Sunnica Ltd
2 Crossways Business Centre
Bicester Road
Aylesbury
HP18 0RA

21st January 2022

Application for a Development Consent Order for Sunnica Energy Farm

RE: Advice following issue of decision to accept the application for examination

Drawn LL	Checked DW	Approved NC	Date 17/01/2022
AECOM Internal Project No. 60589004		Scale @ A3 1:18,640

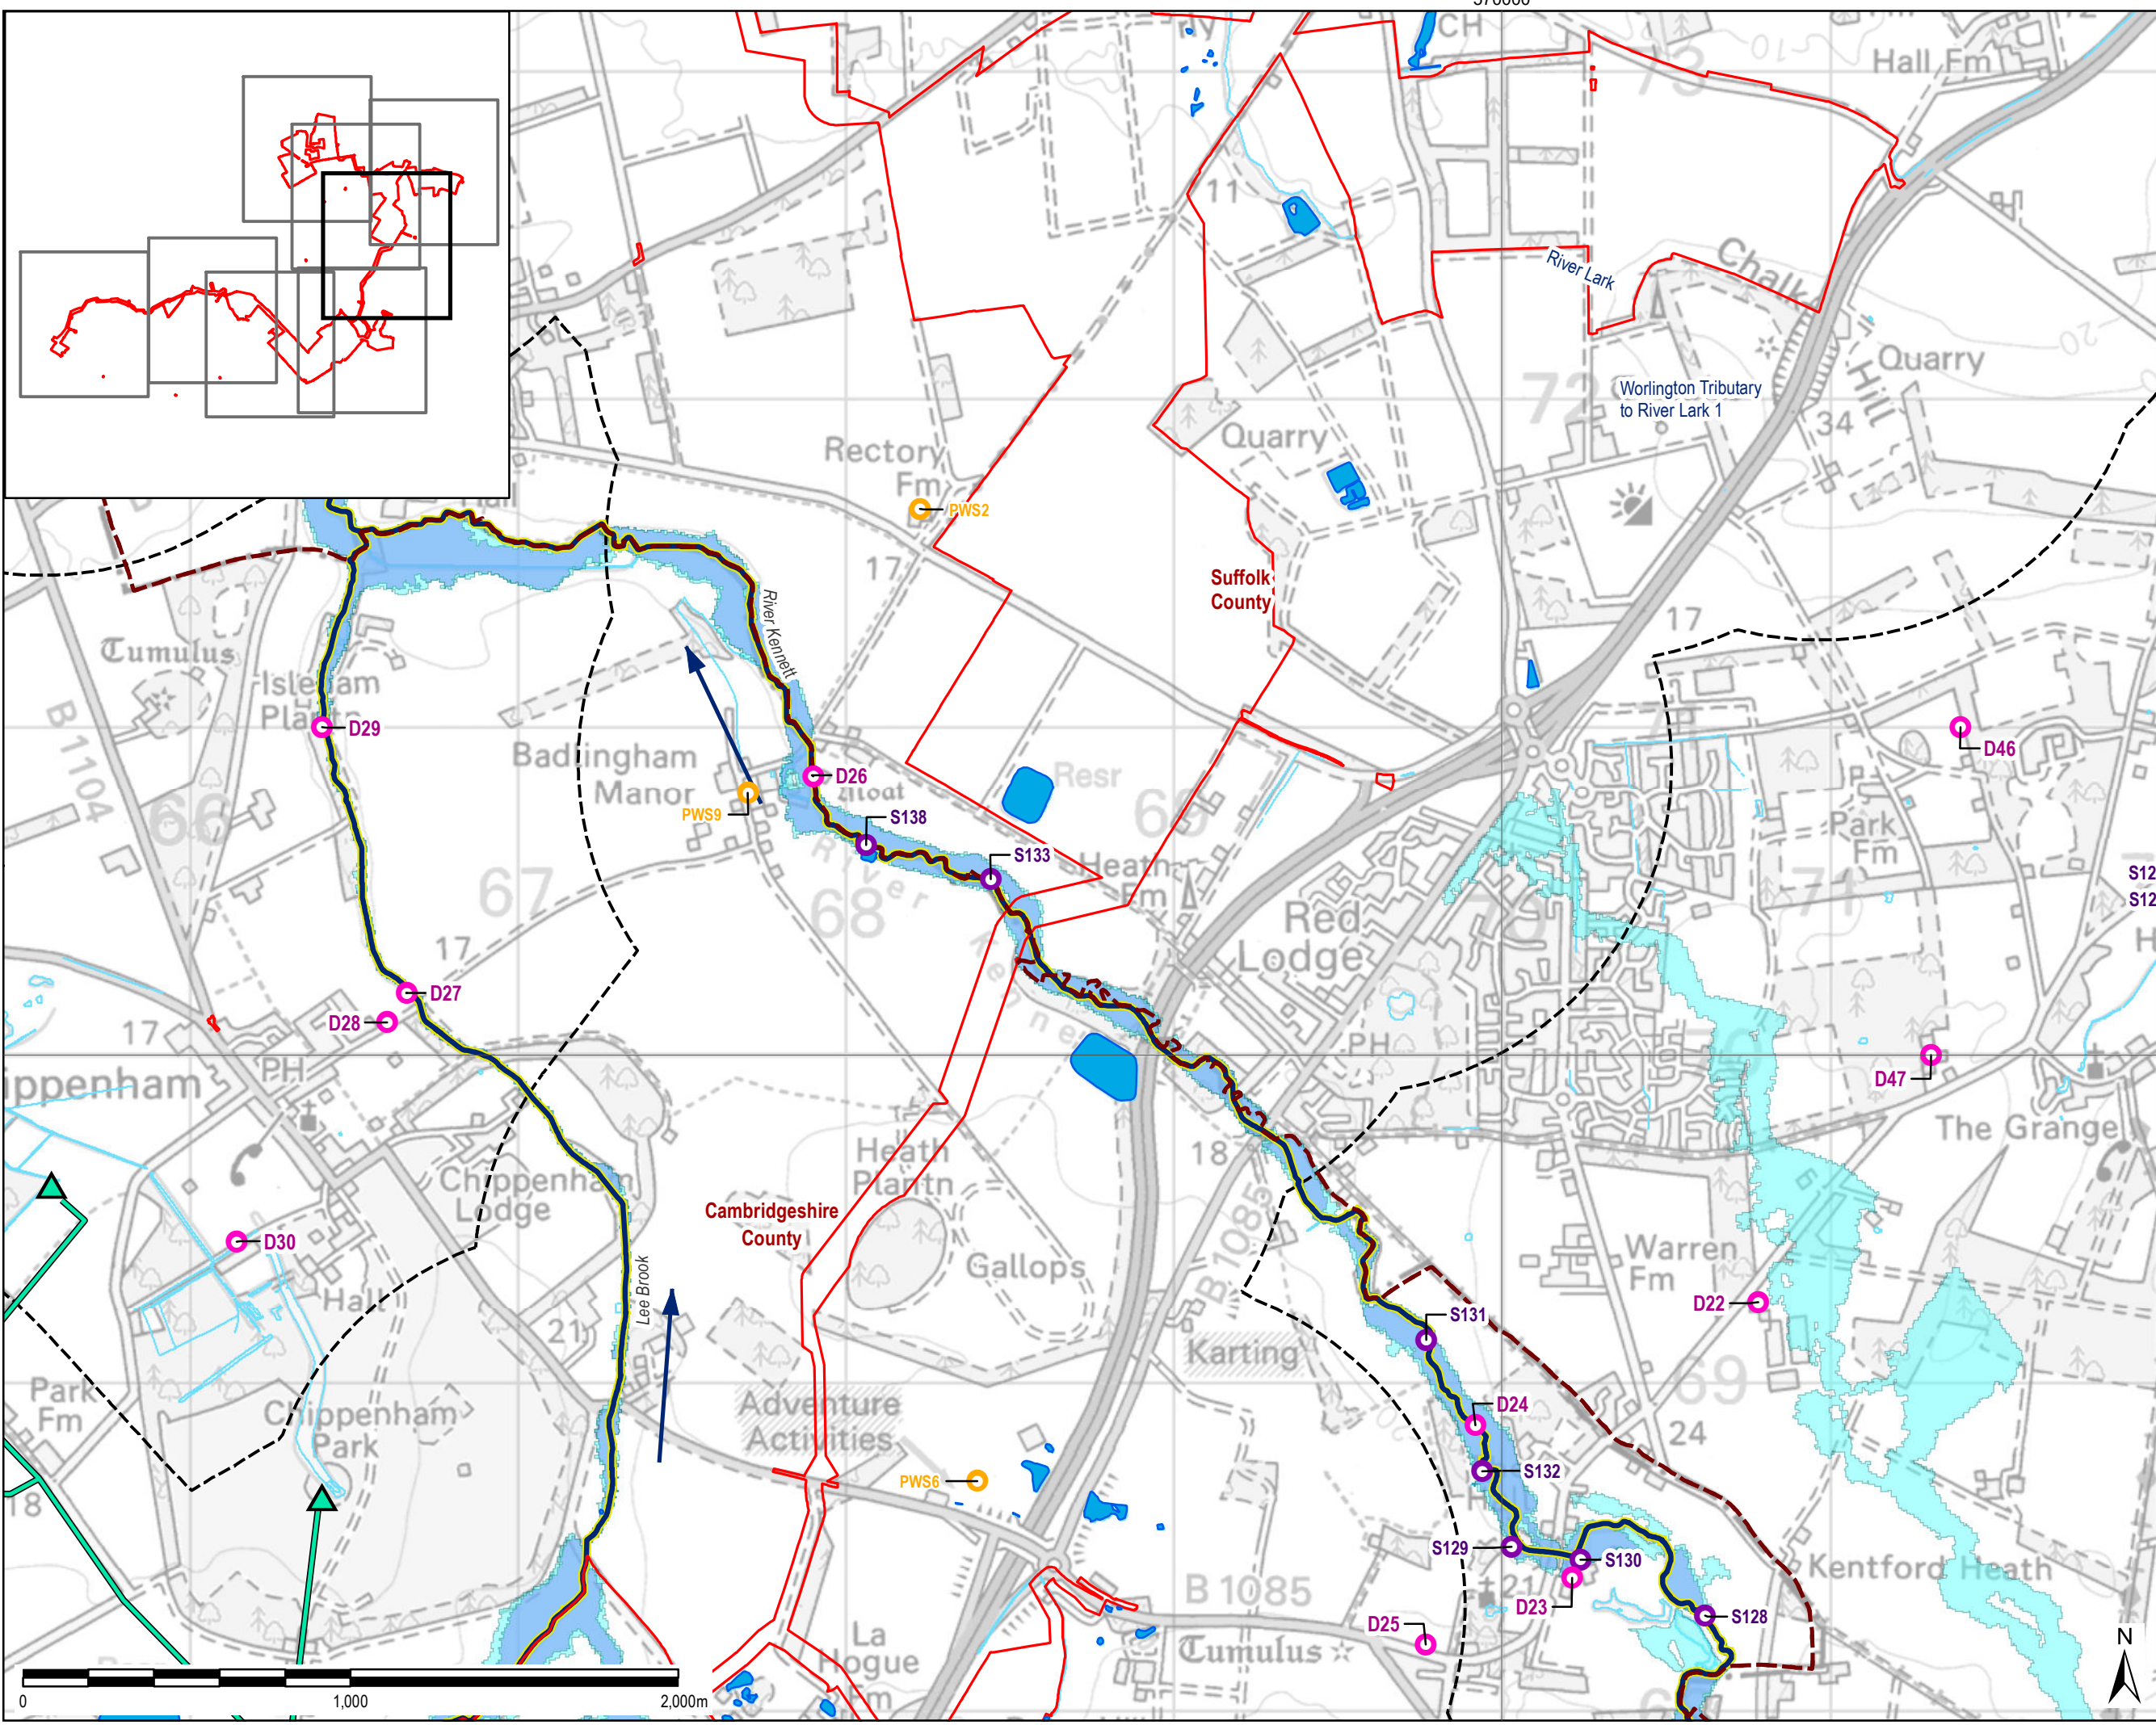
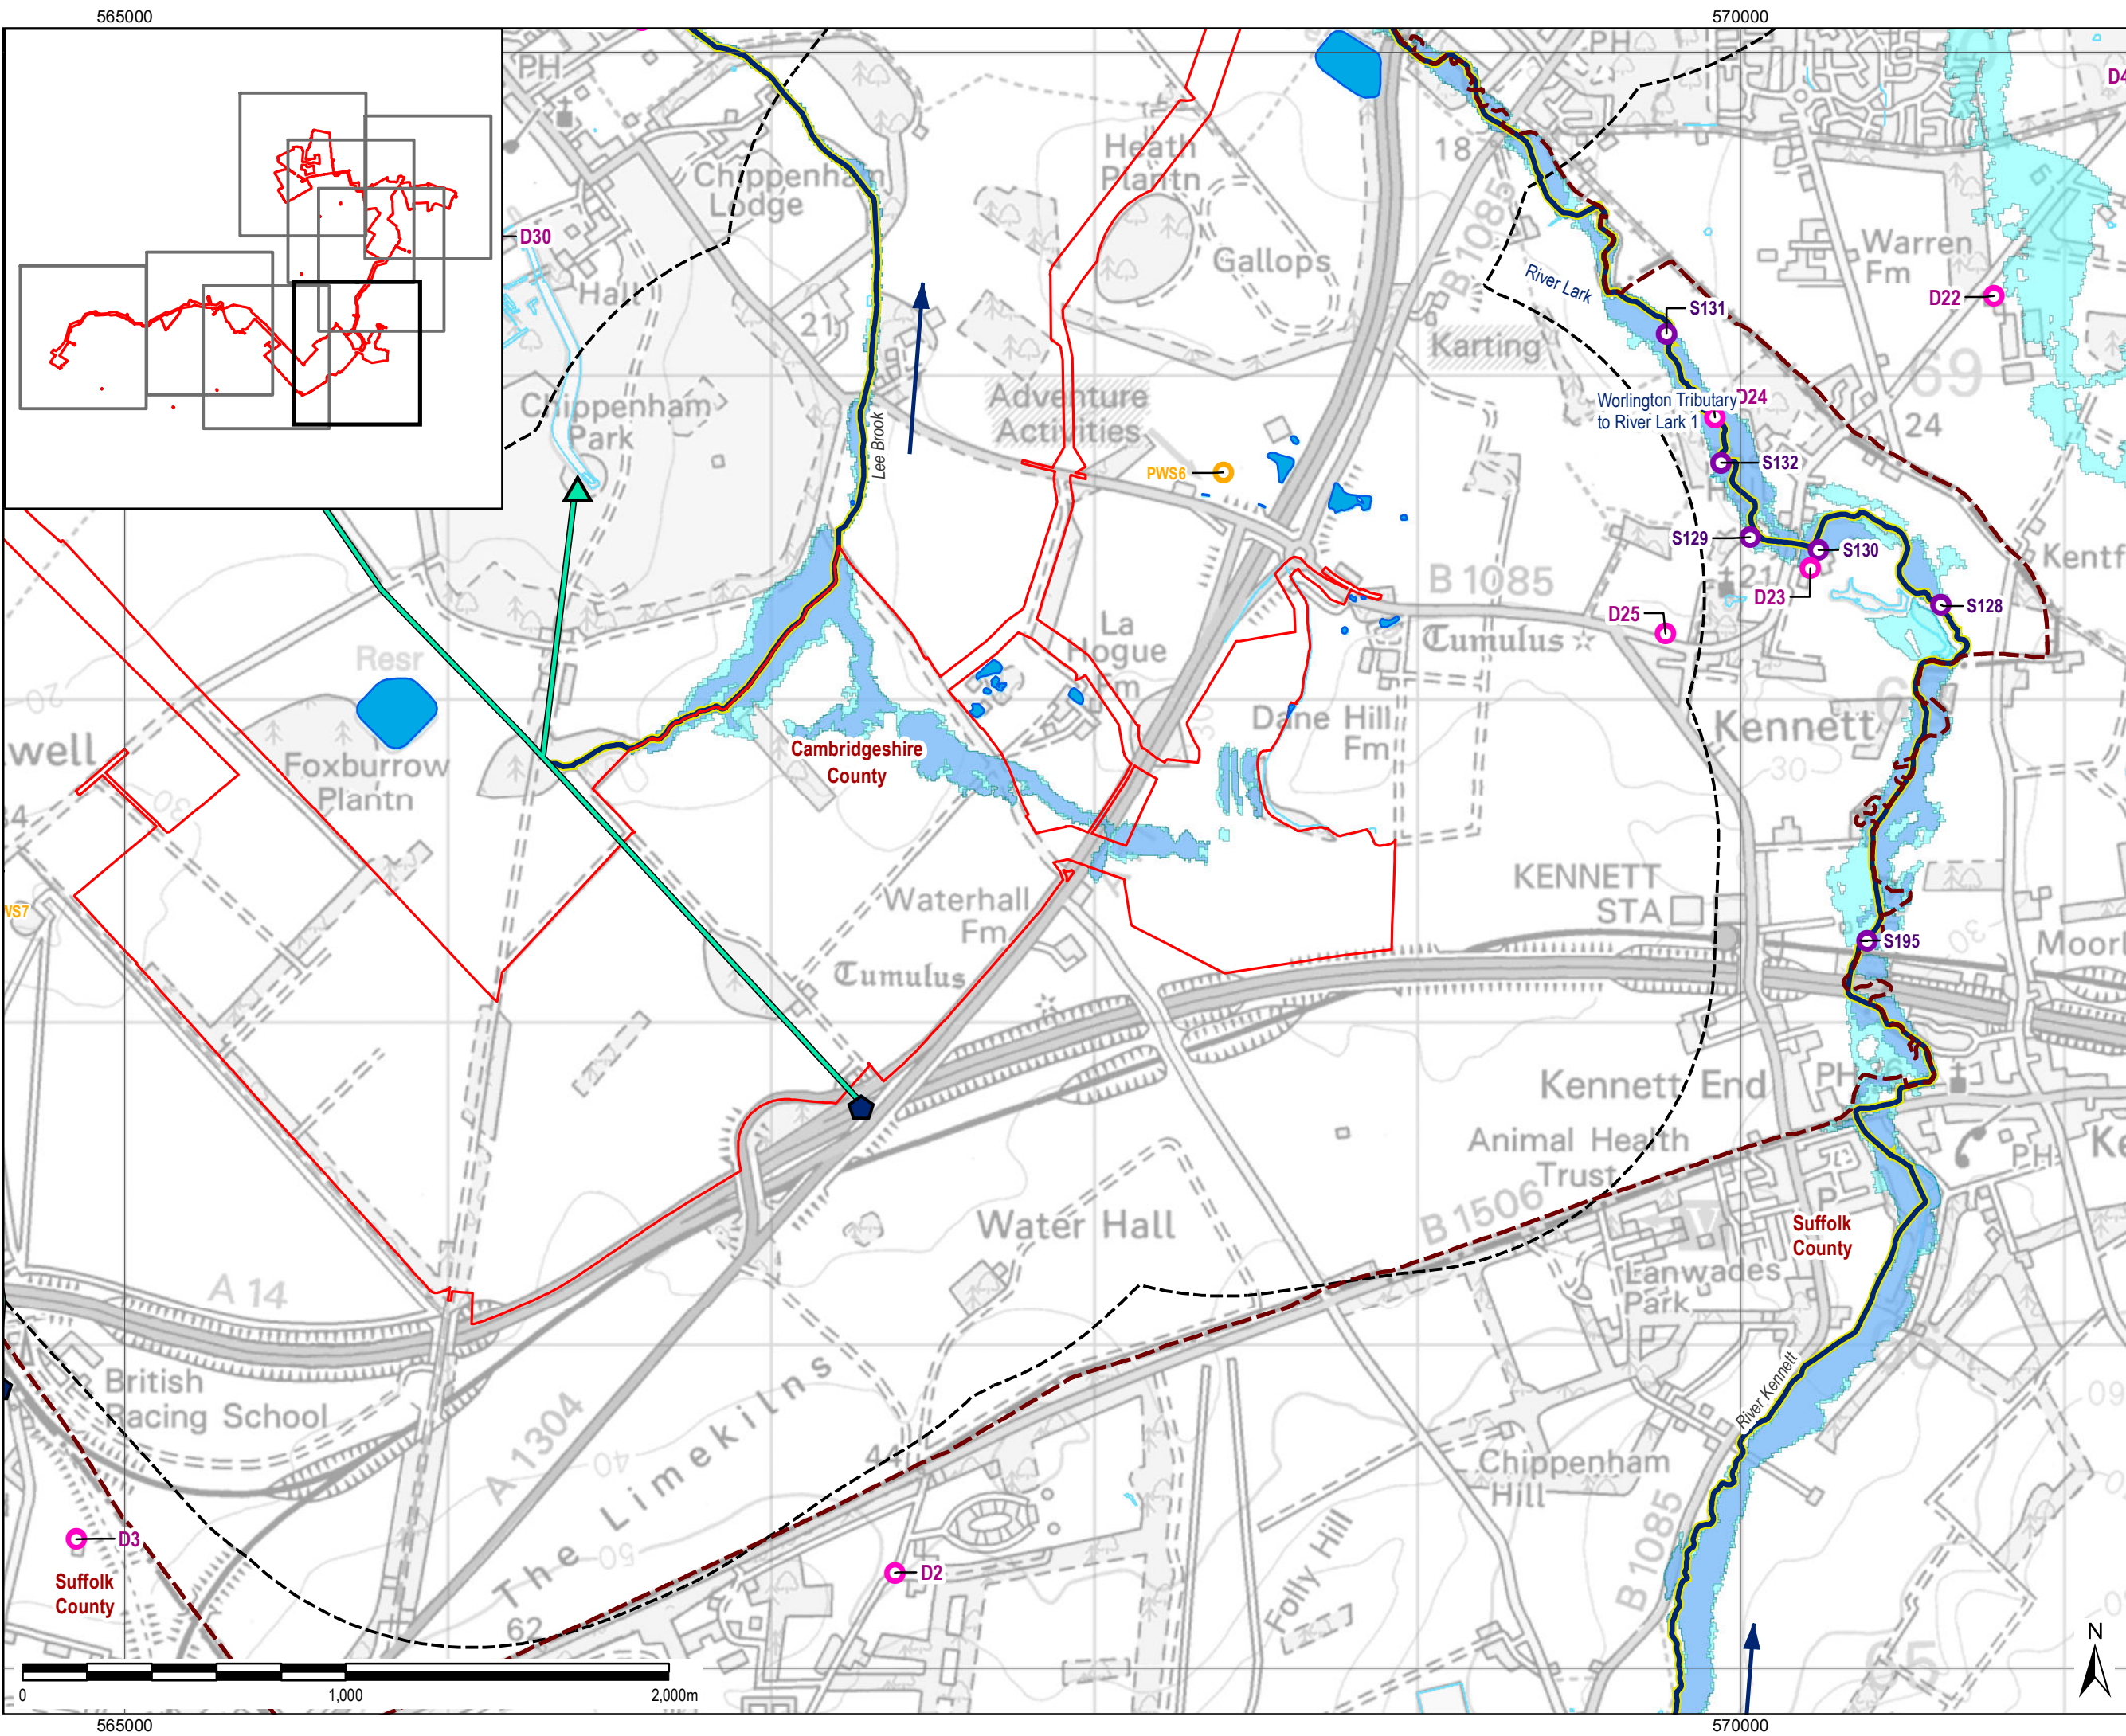
- 1.4.3 Revision 1 of Figure 9-1 of the Environmental Statement [APP-188] is provided to address the advice provided by the Planning Inspectorate.
